SUBJECT: Engineering Review Comment
Mountain View Electric Association Inc. (The Association)

Project Name: Walden Preserve 2 Filing 5 – Final Plat

Project Number: SF2211

WALDEN PRESERVE 2, FIL. NO. 5 - E1/2 SEC. 15 & SW1/4 SW1/4 SEC. 14, T11S, R66W of the 6th P.M., EL PASO COUNTY, COLORADO

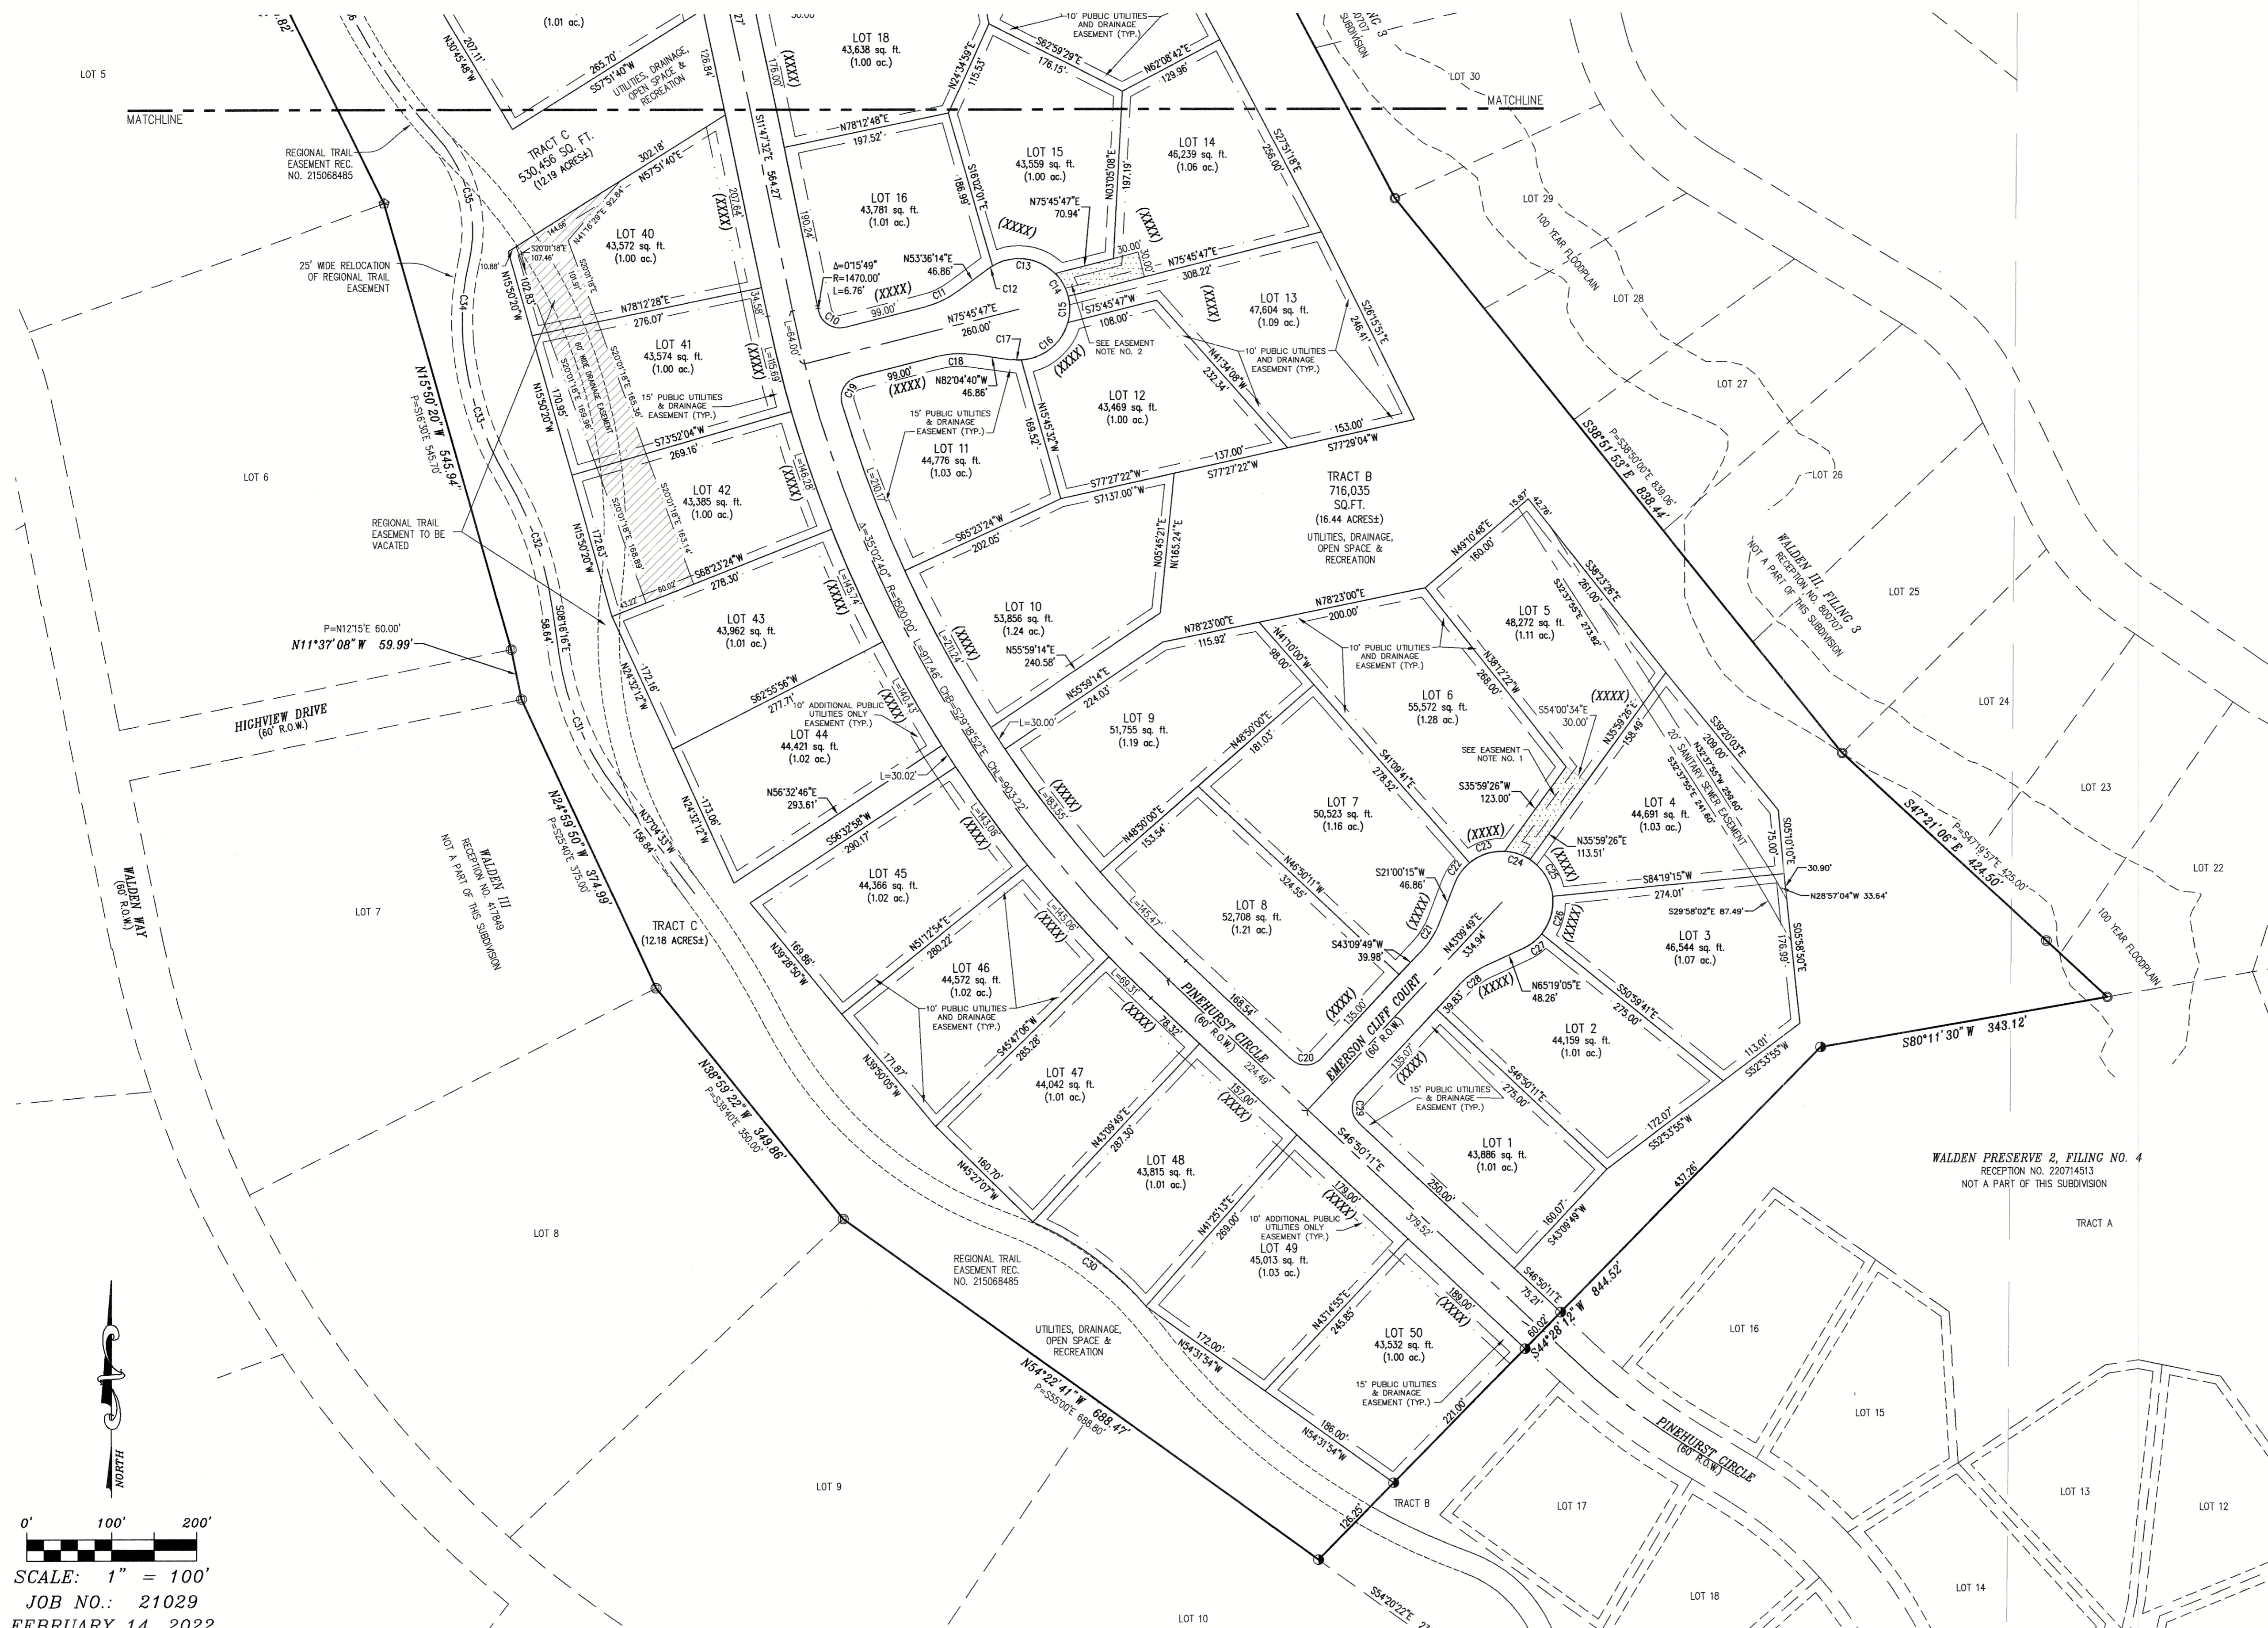
The Association requests a fifteen (15) foot front lot line utility easement and a ten (10) foot side, and rear lot utility easement on the plat and all tracts. The Association also requests the platting of the Association's existing facilities with easements on the plat. Additional easements may be required.
